From: Kim Leslie [REDACTED]
Sent: 12 April 2019 07:19
To: Planning
Subject: Planning Application FP/46/19/PL

Planning Application FP/46/19/PL - 28 Sea Drive, Felpham

We write with reference to this planning application involving a proposed amendment to existing consent FP/205/18/HH.

The Corn Exchange
Baffins Lane
Chichester
PO19 1BF
T 01243 558750
info@hunterssoutharchitects.co.uk
www.hunterssoutharchitects.co.uk
Project Name:
28 Sea Drive, Felpham
Proposed extension & alterations
Dwg Reference:
Elevations as proposed

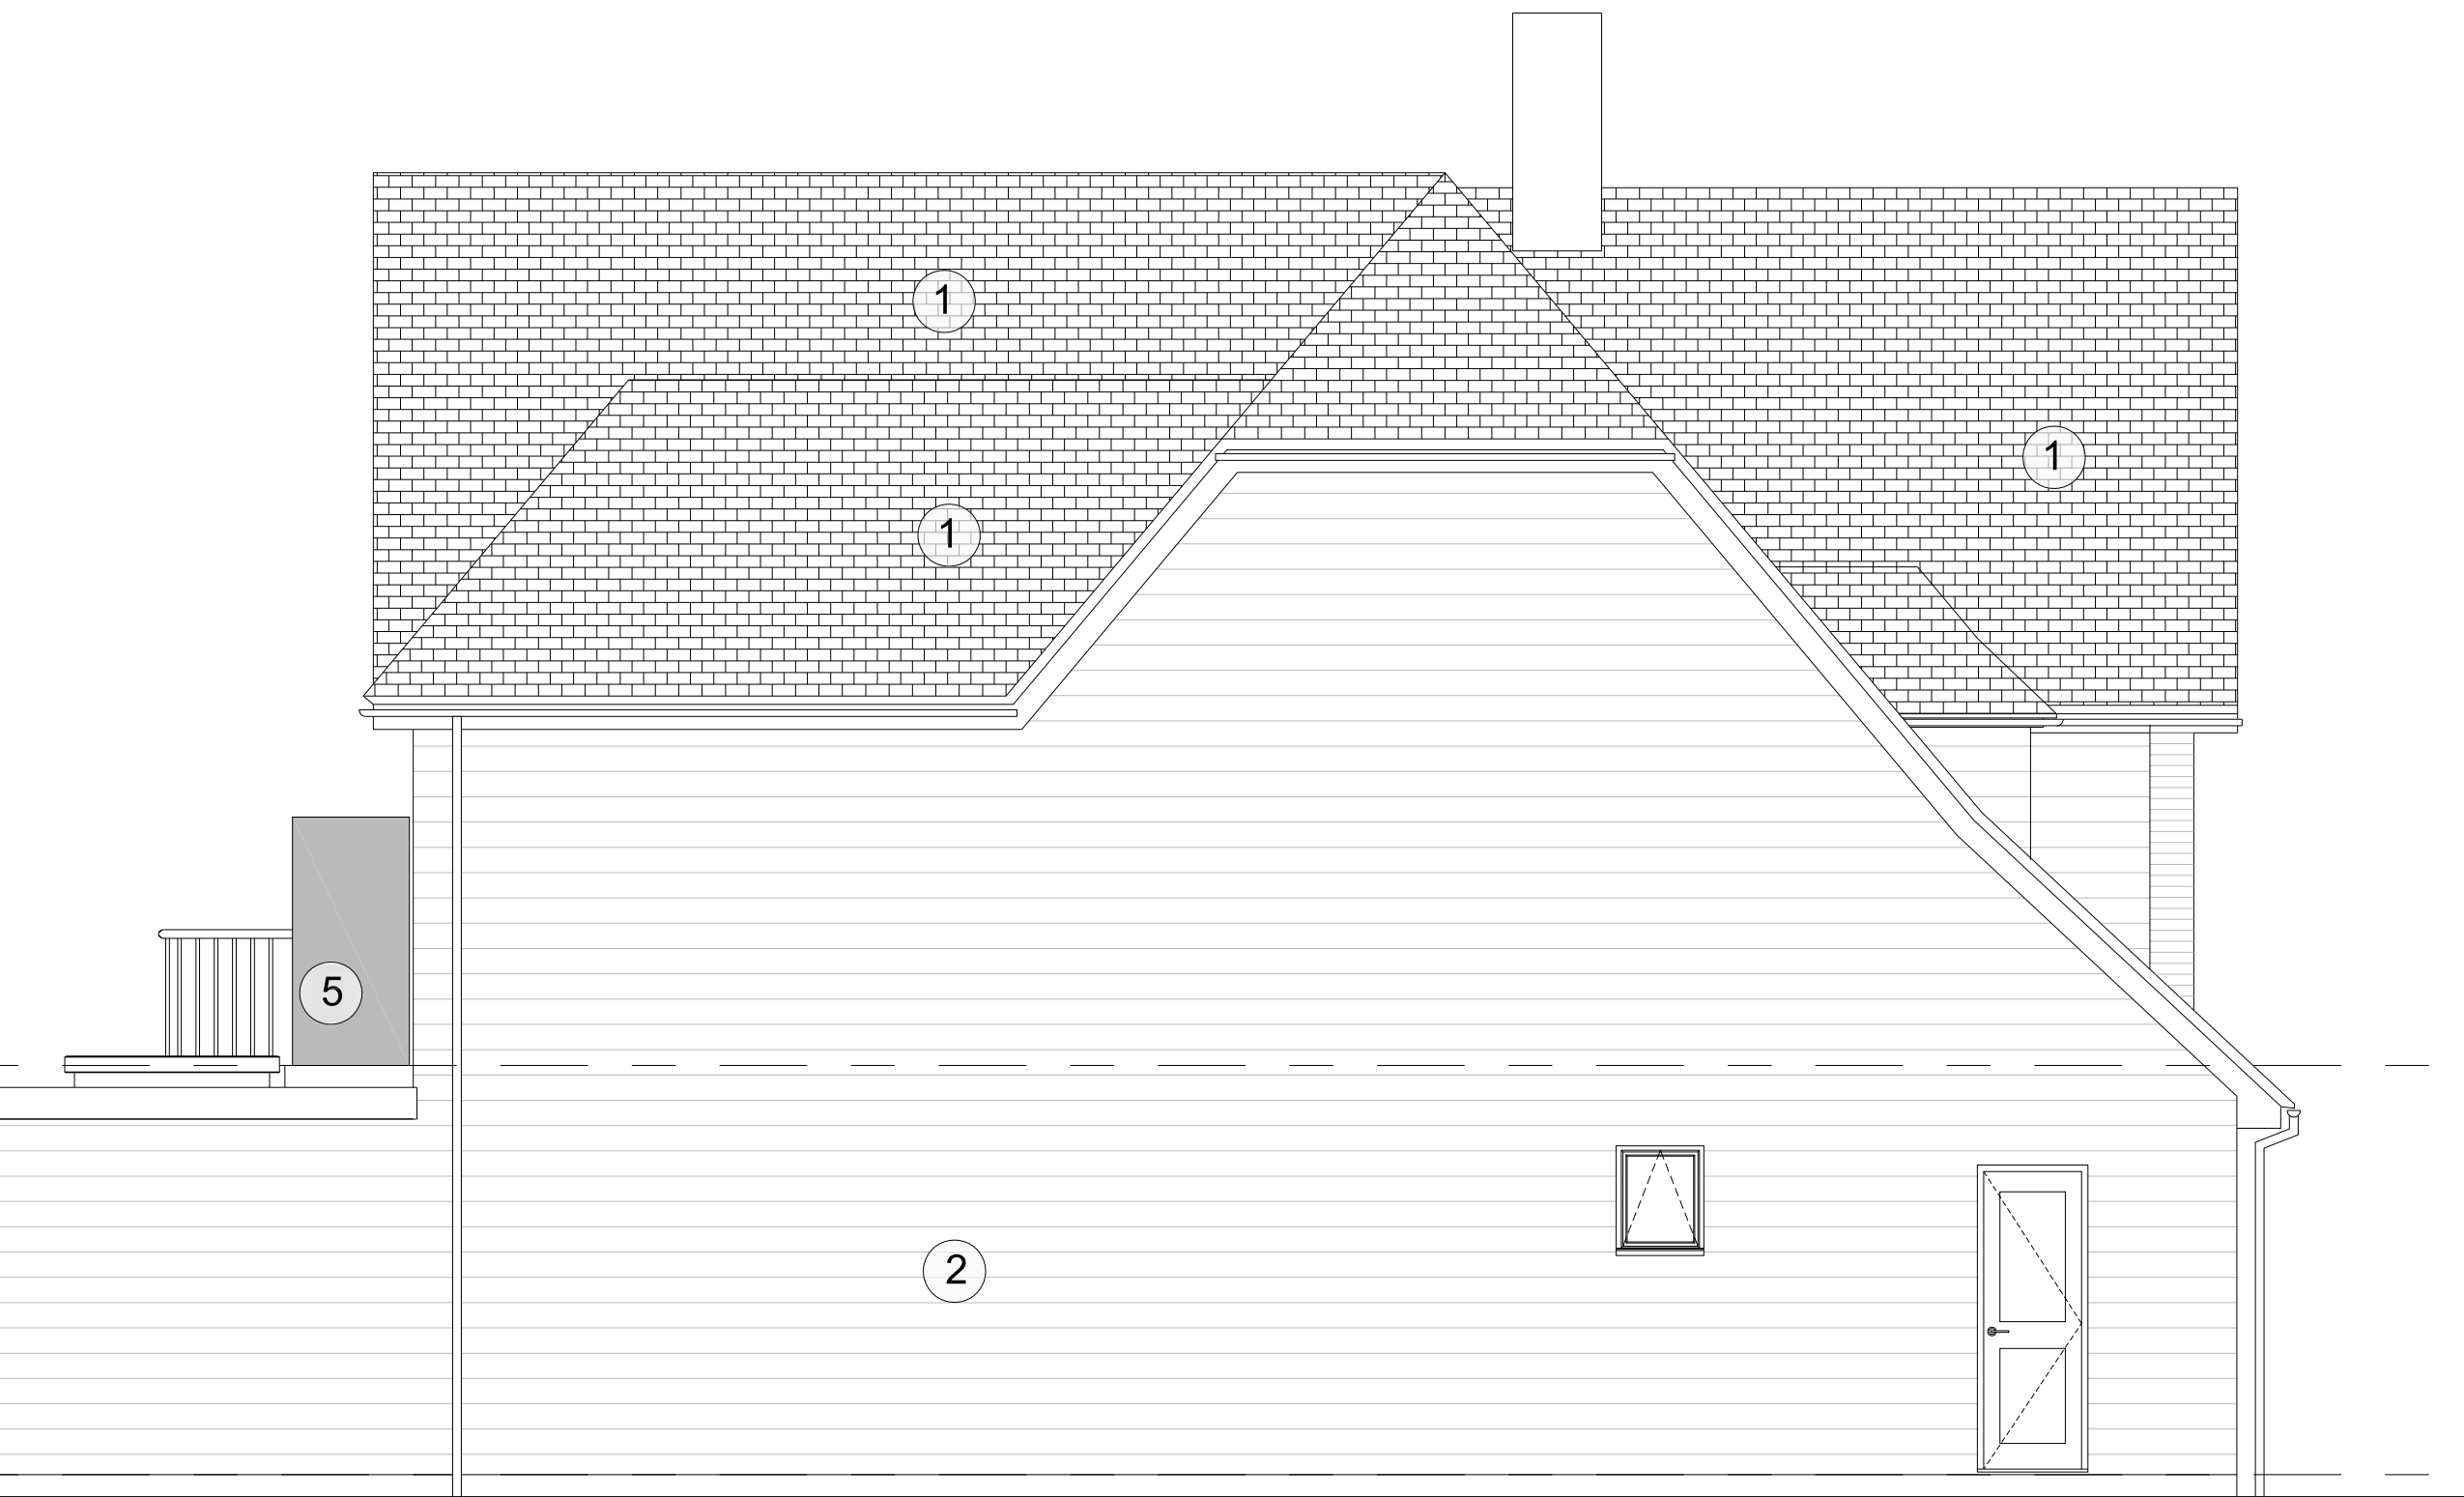
This latest proposal is misleading as the block plan and elevation plan are at variance with each other.

We note that the proposed west and east elevations indicating obscured glass panels at each end show that only half their length are drawn at full height, the other half of each end is shown at half this height which again compromises our privacy.
